## The Planning Inspectorate Yr Arolygiaeth Gynllunio

### **Application by AQUIND Ltd for the AQUIND Interconnector**

#### **The Examining Authority's first written questions**

**Illustrative converter station layout and equipment included in noise model**

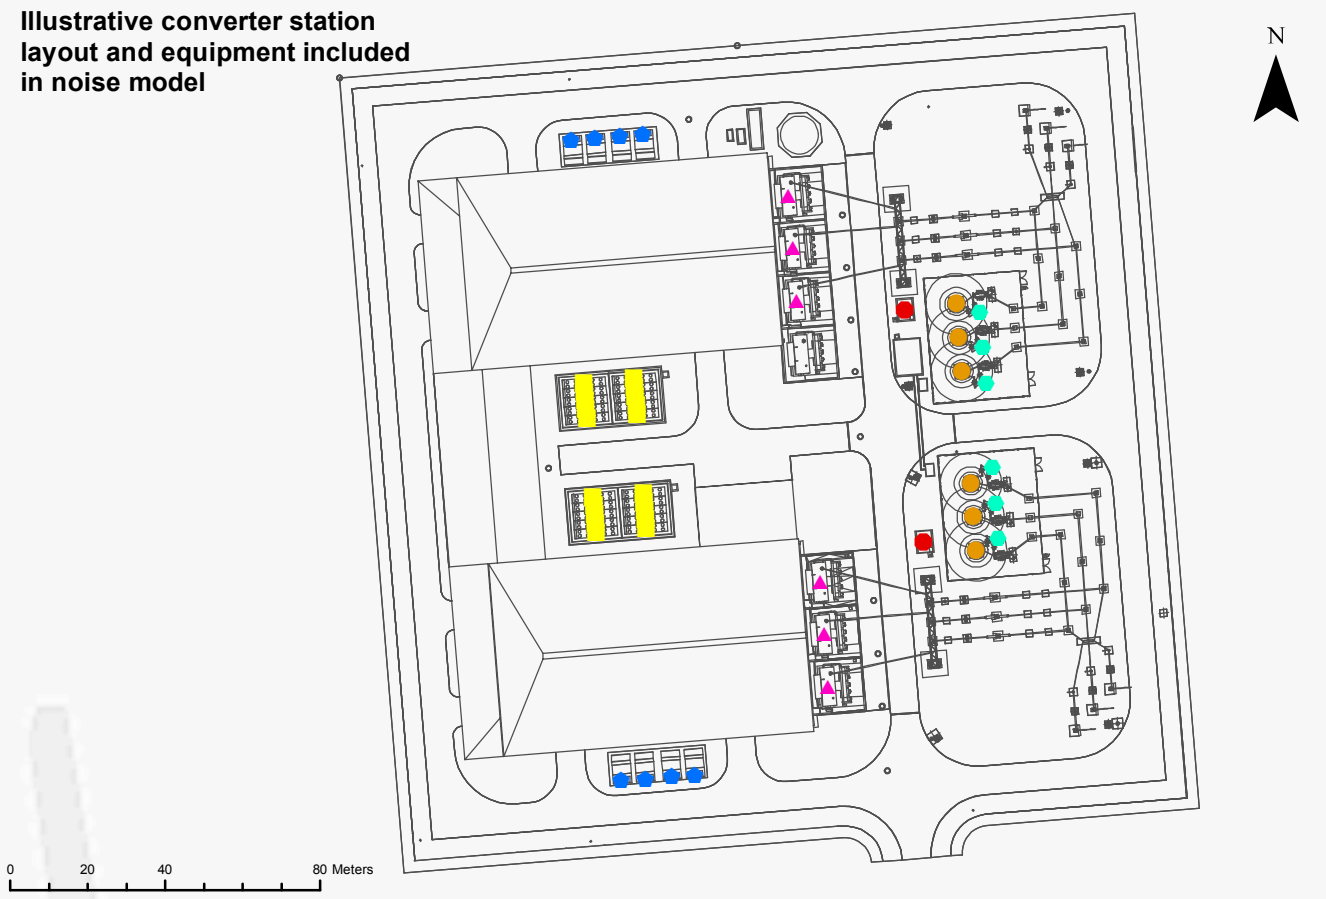
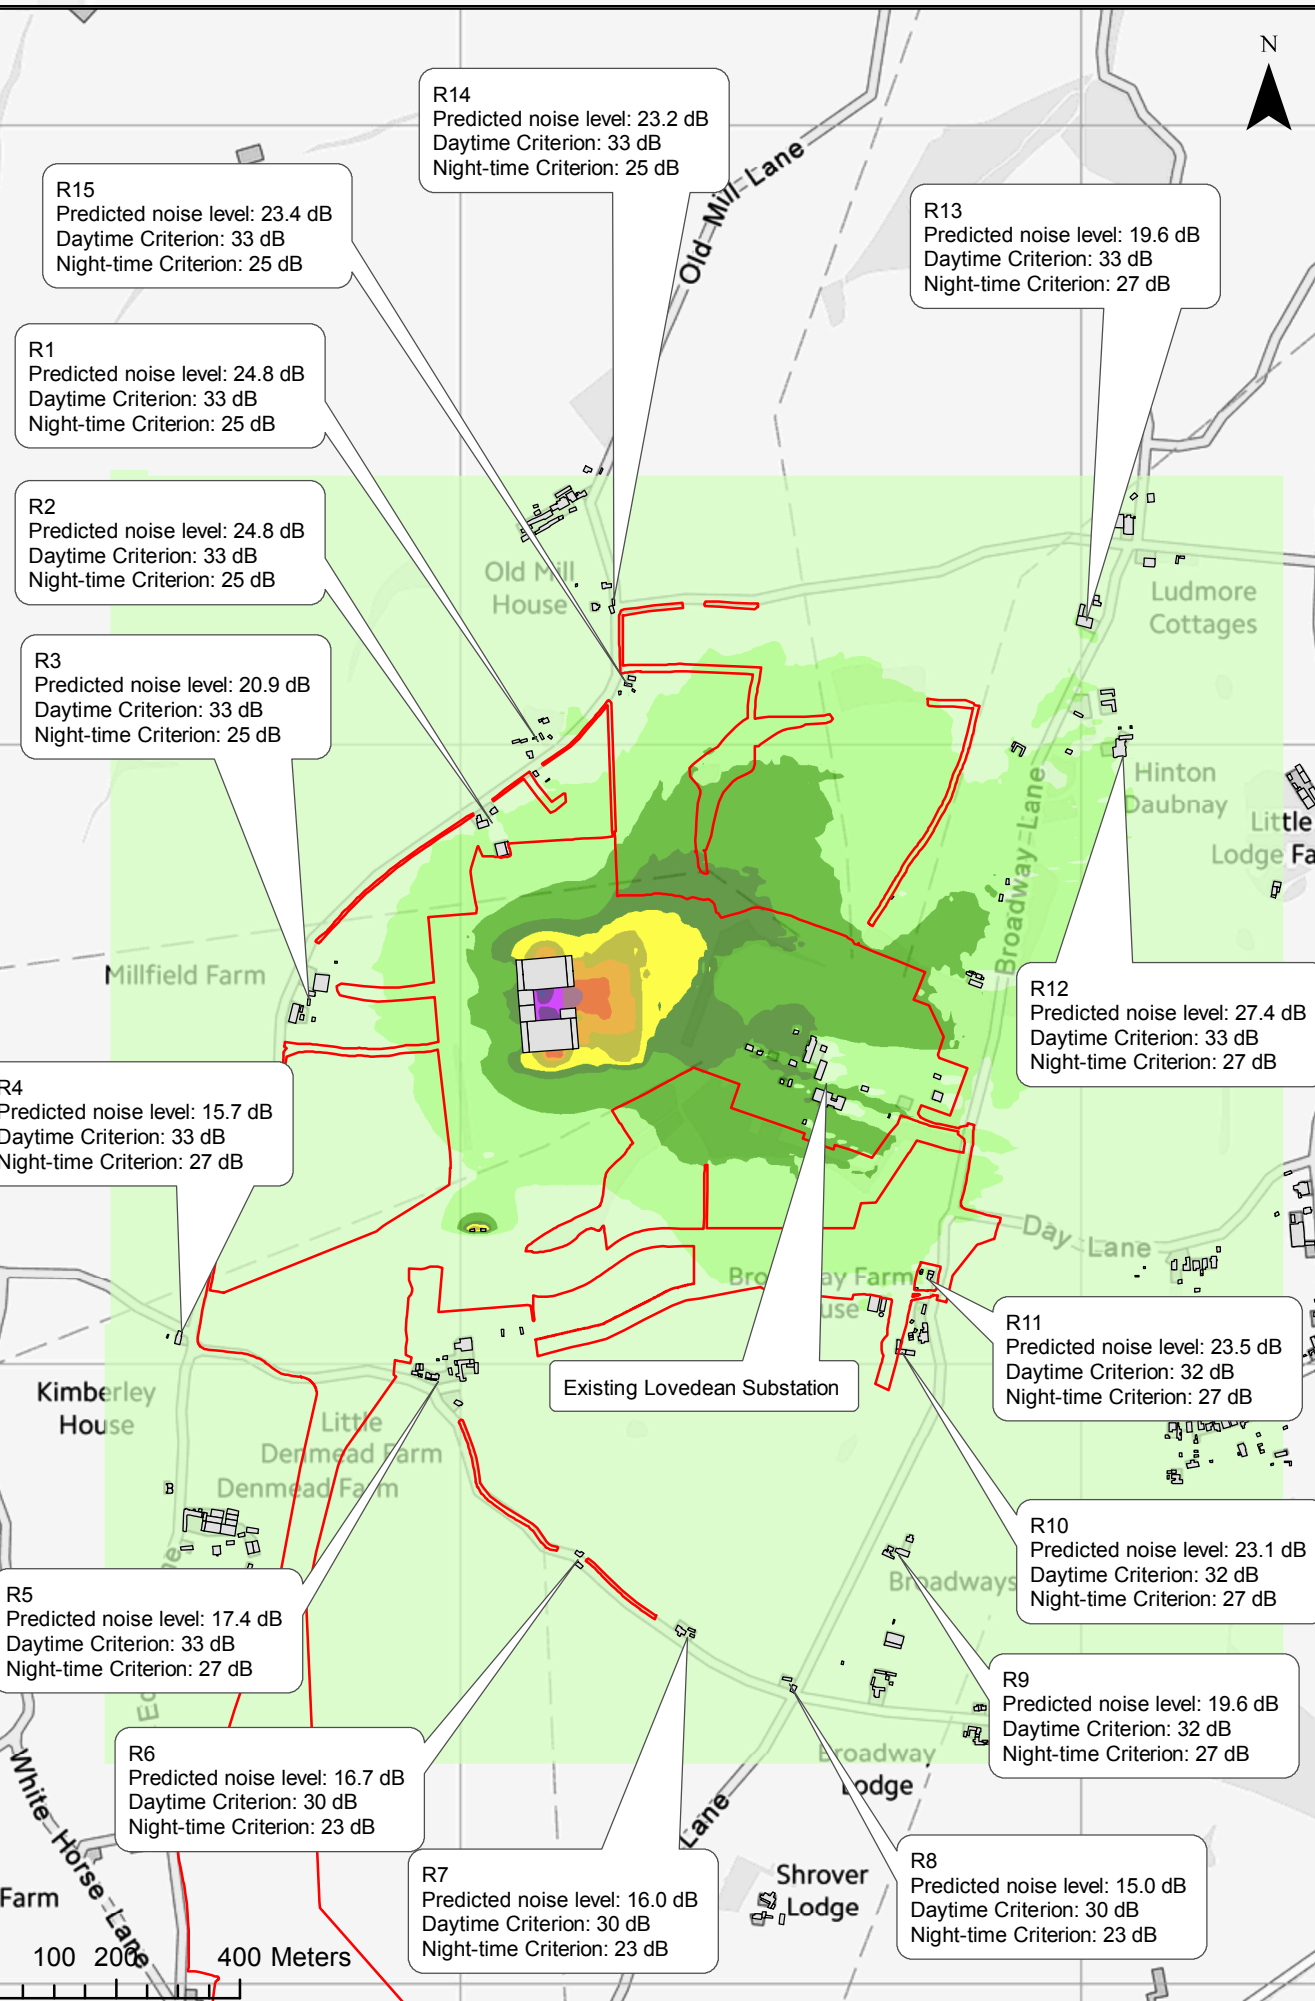
11. Noise			
N1.11.2	Relevant local authorities	<p>Is each affected local authority content with the approach and methodology used for undertaking the construction and operational noise assessments, particularly the location of survey points at the Converter Station and Optical Regeneration Station sites relative to the identified noise-sensitive receptors?</p>	<p>Having reviewed the survey location points and discussed them with the acoustic consultants to understand why they were chosen, we are satisfied that they have identified the most sensitive receptors.</p>
N1.11.5	Relevant local authorities	<p>In ES Tables 24.4 and 24.6 [APP-139], the allocation of a category for the magnitude of impact is wholly dependent on how many 'consecutive' periods would be involved. Do the local authorities</p>	<p>Having reviewed Tables 24.4 and 24.6, it</p>

Reference	Respondent(s)	Question	Response
		believe this is an appropriate approach, or should some account be taken of the overall, total length of time (perhaps with breaks) that the noise or vibration affects a particular receptor?	is agreed that additional clarity is required, in particular to confirm what the period is, and also it is agreed that the approach currently in place could lead to some receptors' "experience" being under-represented, because there are "breaks" in between noisy periods. We will be asking for clarity on this matter from the Consultant.
N1.11.7	The Applicant Relevant local authorities	Do you believe that the application of definitions of magnitude of impact to the noise environment as set out in Table 24.13 of the ES [APP-139] is unclear? For example, what would constitute 'a total loss' of key elements or features of the baseline? Would an alternative set of definitions be more appropriate, and if so, would the noise assessment need to be re-run?	It is considered further clarity is required and this might lead to a requirement for the assessment to be rerun. We will be asking for clarity on this matter from the Consultant.
